CITY OF ALBUQUERQUE

July 8, 2016

**RE: 2900 A&B Corona NW
Grading and Drainage Plan
Engineer's Stamp Date – 6-6-2016
Hydrology File: H11D070**

ENGINEER'S SEAL  6/6/16 DAVID SOULE P.E. #14522	2900 A&B CORONA DRIVE GRADING AND DRAINAGE PLAN	DRAWN BY WCVJ DATE 6-05-16 21625-LAYOUT-6-05-16
	 1606 CENTRAL AVENUE SE SUITE 201 ALBUQUERQUE, NM 87106 (505) 872-0899	SHEET # JOB # 21625

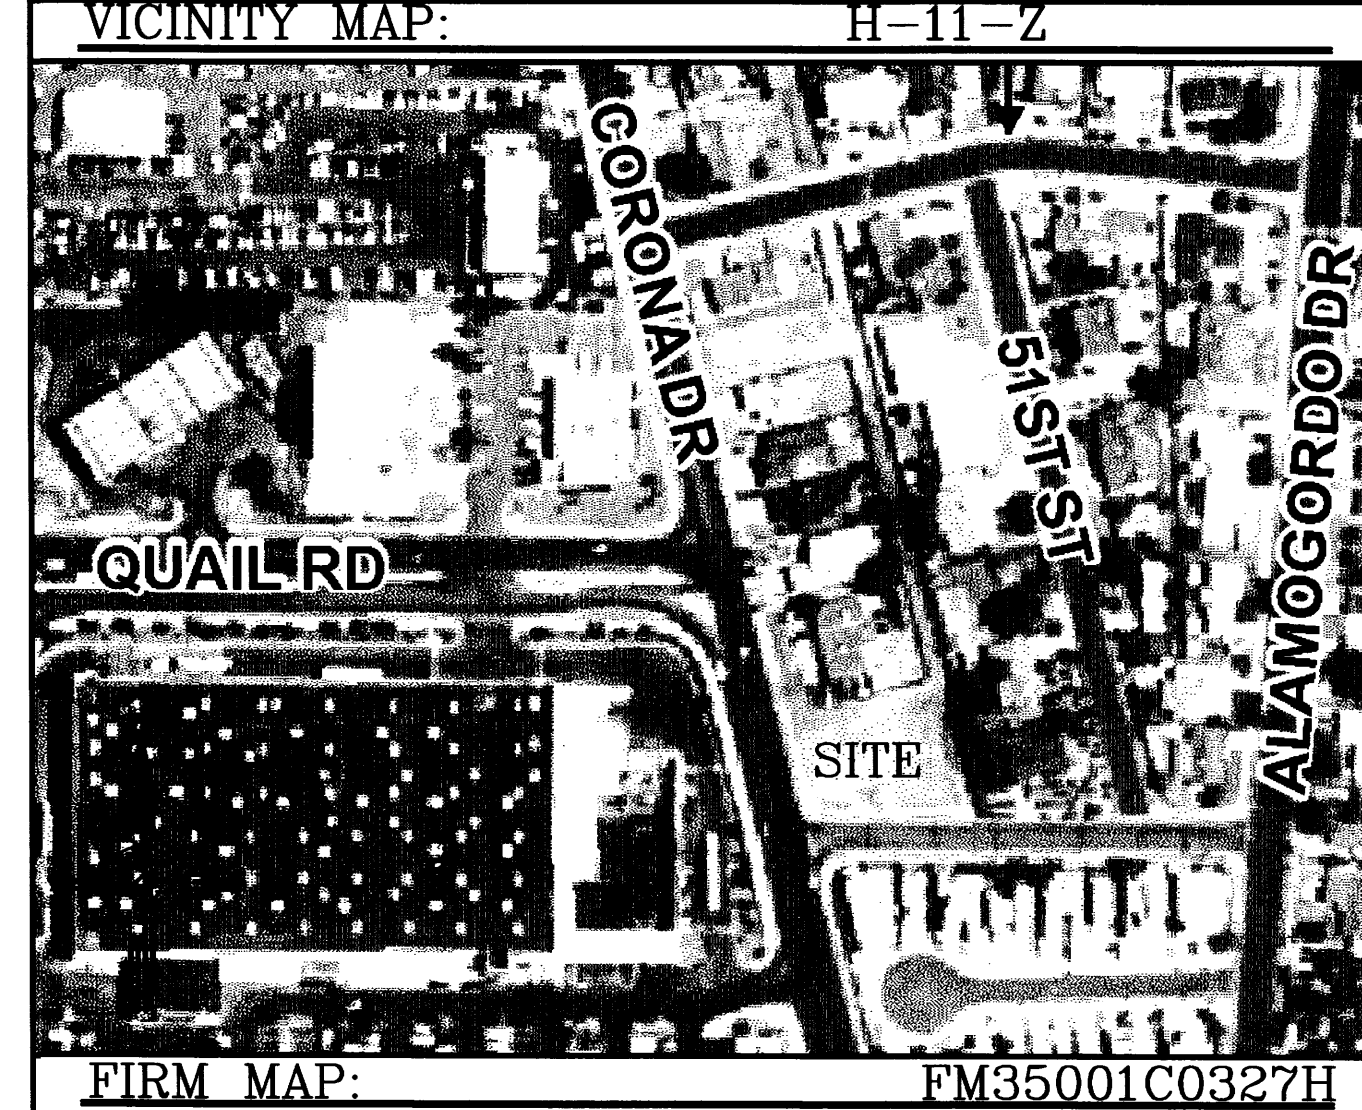
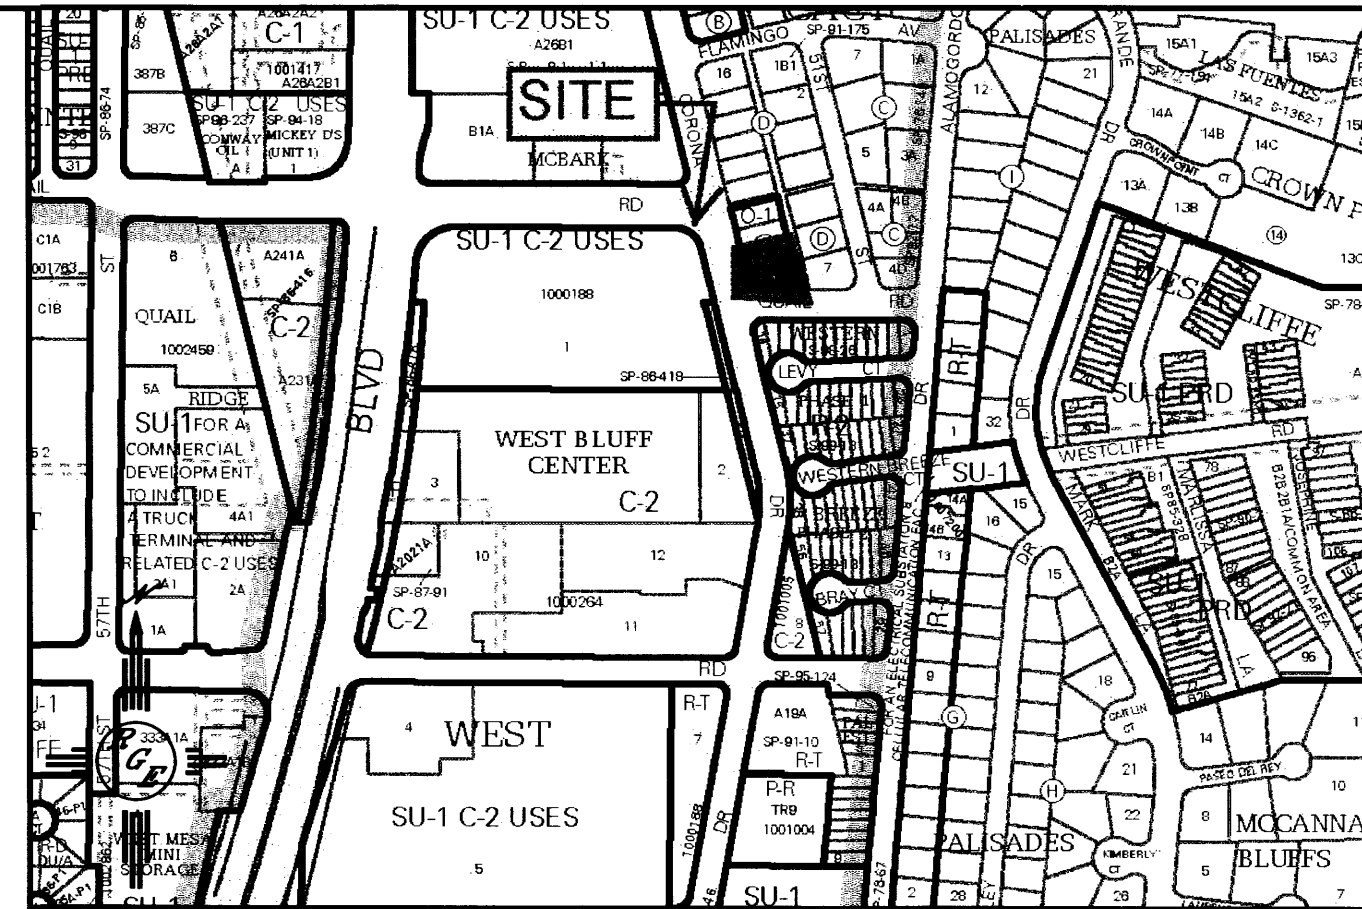
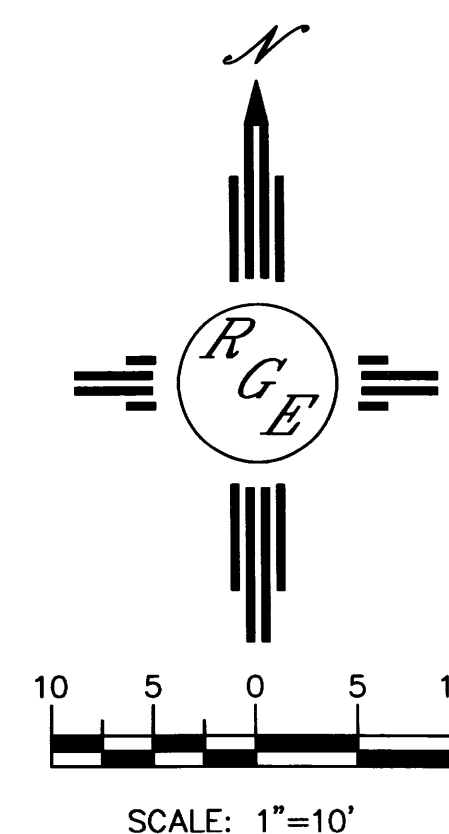
- The location of roof drains is not shown, but it appears that they will be directed North and South. Ensure that roof flows are routed through the first flush ponds.
